Consultation Response from KC, Highways Development Management (HDM)

2023/90075 & 2023/90076 Units A&B, Leeds Road Retail Park, Leeds Road, Huddersfield, HD1 6PF

Date Responded: 21/03/2024 | Responding Officer: A Darwin | Responding Ref: HDC 5-11NW/21

RECOMMENDATION: No objection, subject to conditions

date **April 2021**
status **Planning**
scale **1:500 @ A3**
drawn **BM** checked **PH**
job no. **2905** dwg no. **P403** rev. **H**

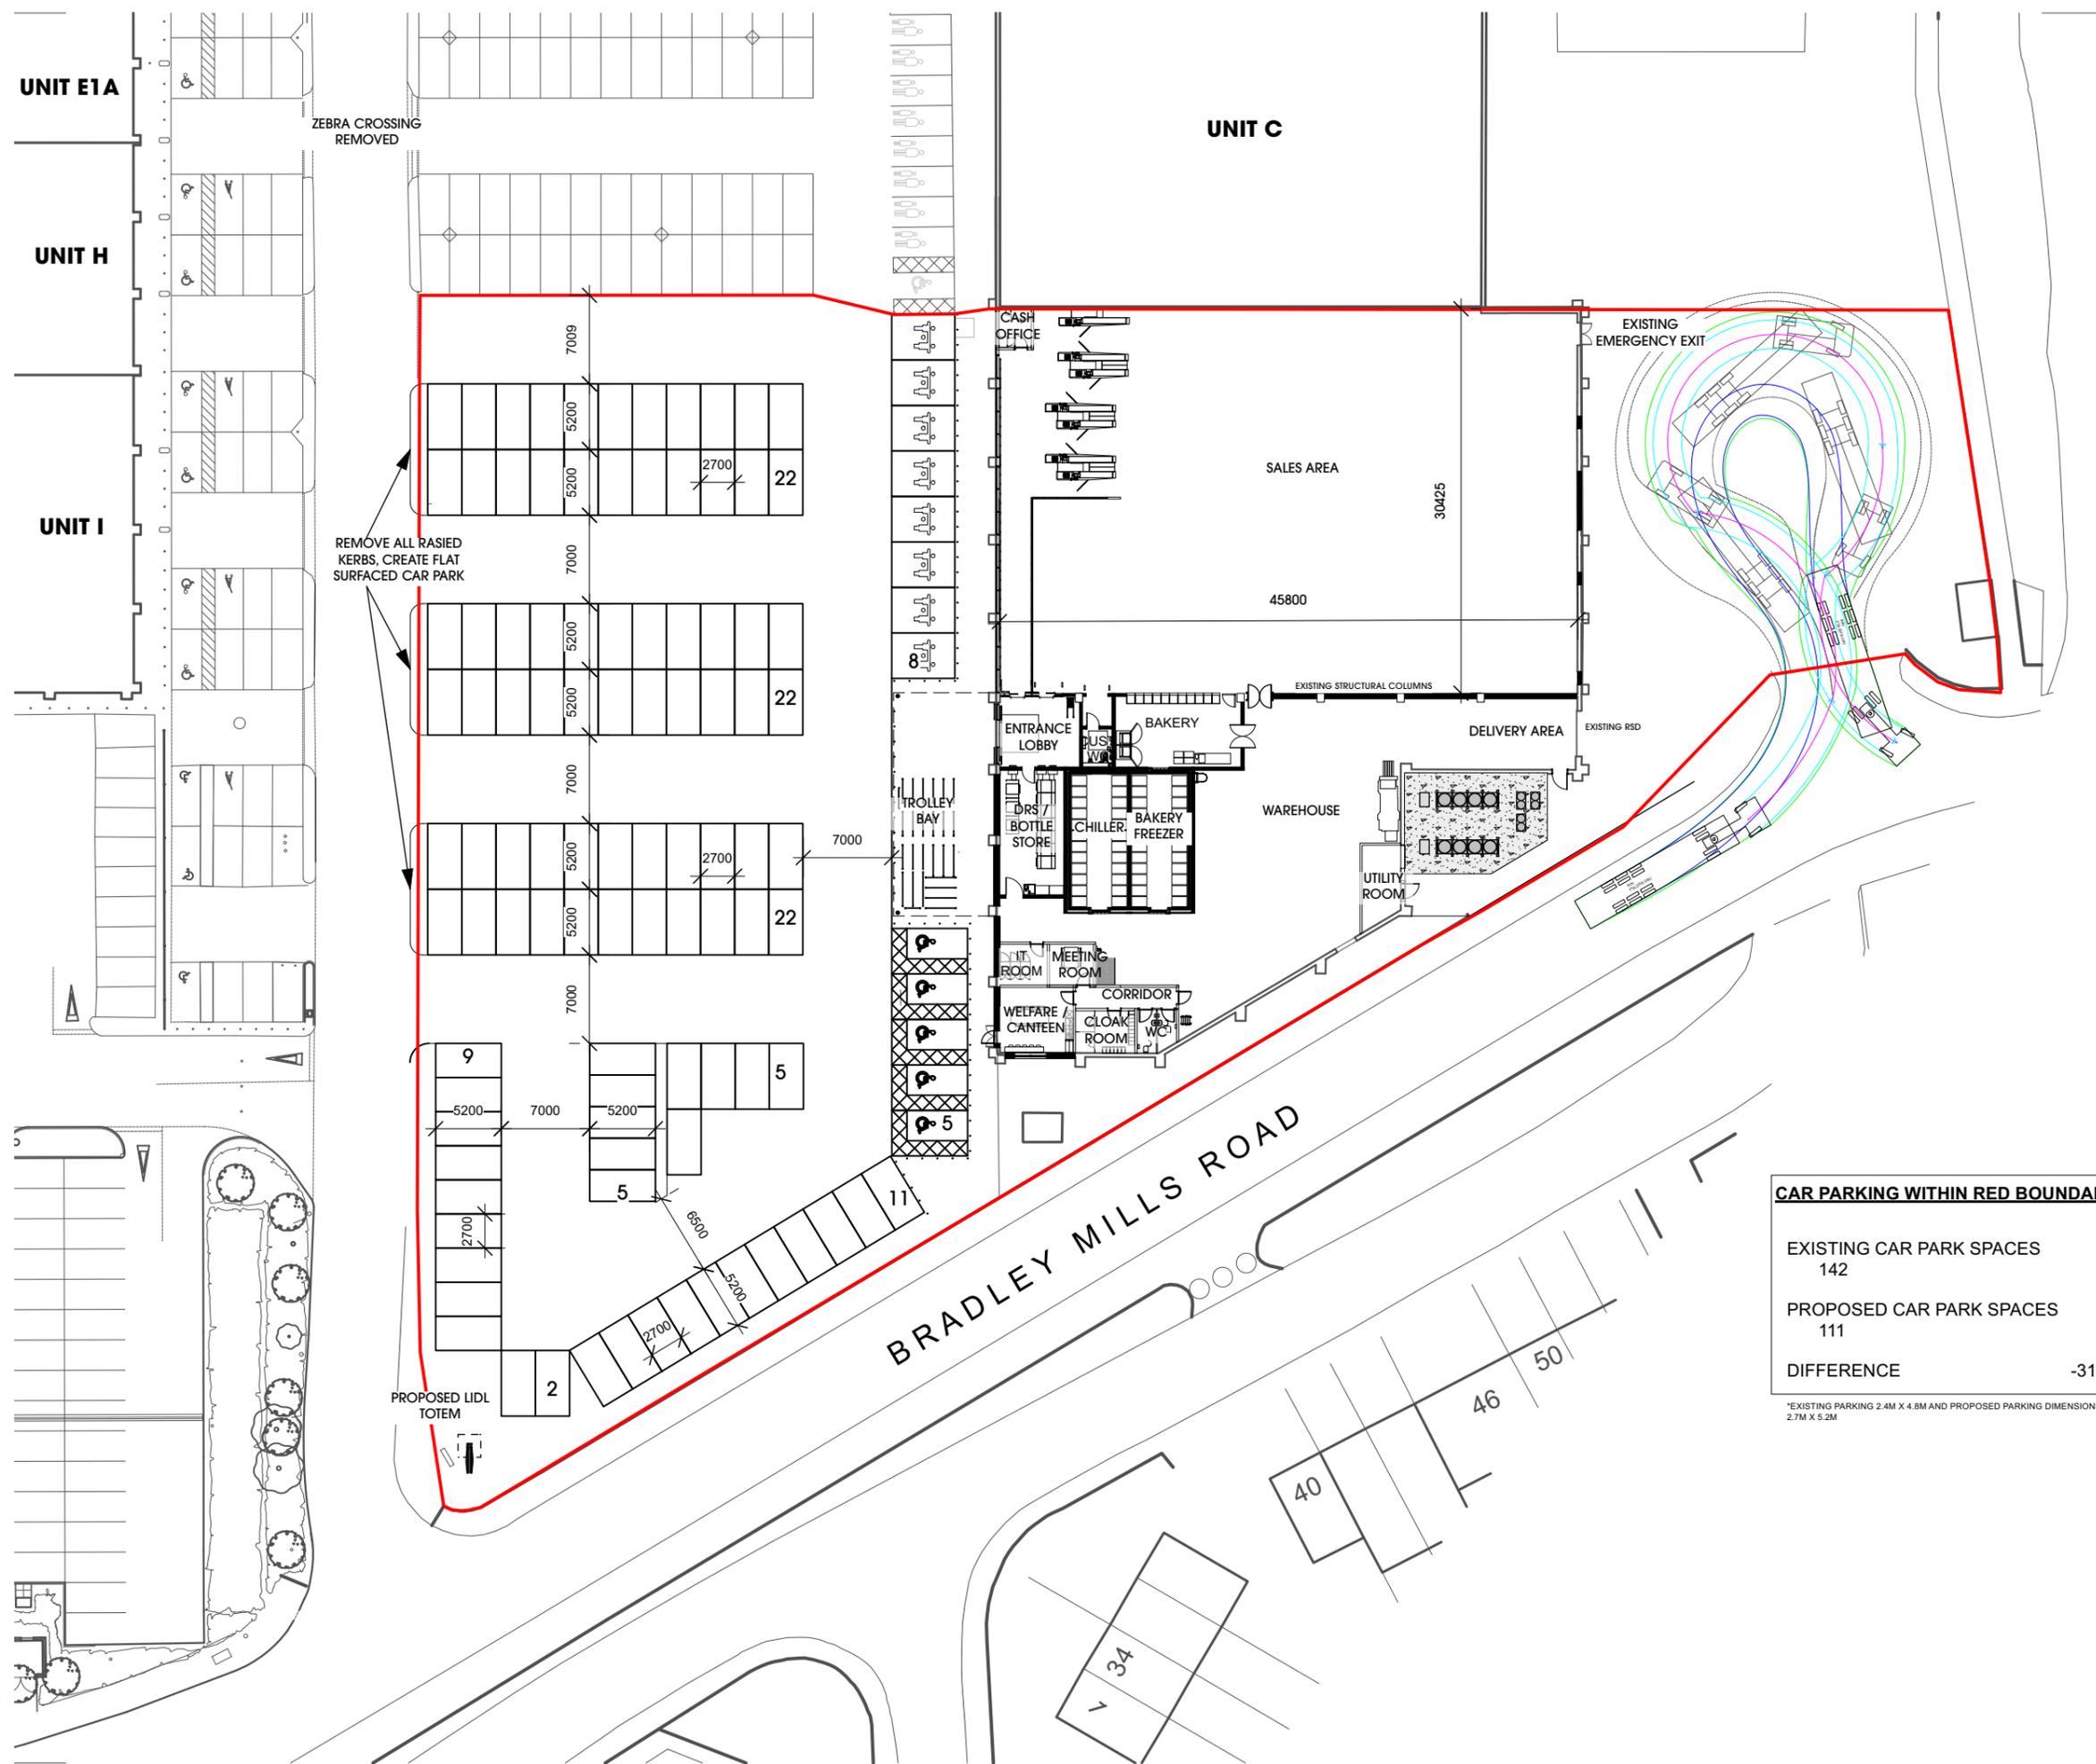
The main highways and transport implication of the proposal are the changes to the proposed car parking, which result in a loss 31 parking spaces. However, the proposals demonstrate that 111 spaces would remain that directly front the amalgamated unit A and B, which HDM consider is sufficient to accommodate the proposed food retail unit, particularly as the car parking layout is proposed to be improved with larger parking spaces and wider aisles that should make the parking arrangements operate more efficiently.

Therefore, HDM have no objection to the reduction in parking spaces numbers, subject to the car parking still being used on a communal basis with the wider retail park, which appears to be the case based on the proposal plans (e.g. as there is no segregation between the adjacent parking area to the north).

The proposed car parking arrangements include the provision of 5 disabled / accessible parking spaces, which appears to be a reduction from the existing provision of 9 spaces within the applications redline boundary. This is not considered to be adequate and should be increased to a minimum of 7 disabled / accessible parking spaces (6% of the overall provision) in accordance with DfT guidance document 'Inclusive Mobility'. The 2 additional disabled / accessible parking spaces could be accommodated by reallocation of 2 of the proposed parent and child spaces to the north of the store entrance (that are currently disabled/accessible parking spaces). Therefore, these changes can be secured by planning condition.

The supporting Transport Statement suggests that secure cycle parking will be provided for the development. However, none appears to be shown on the site plan. Therefore, the provision of secure, covered cycle parking for customers and staff should be secured by condition, with a minimum of 11 spaces recommended (e.g. equivalent to 10% of the car parking provision).

The development shall not be occupied until the details and provision of a minimum of 7 disabled / accessible car parking spaces have been submitted to and approved in writing by the Local Planning Authority. The disabled / accessible car parking spaces shall then be implemented prior to occupation of the development and maintained thereafter.

The development shall not be occupied until the details and provision of a minimum of 11 secure, covered and inclusive cycle parking facilities have been submitted to and approved in writing by the Local Planning Authority. The cycle parking provision shall then be implemented prior to occupation of the development and maintained thereafter.
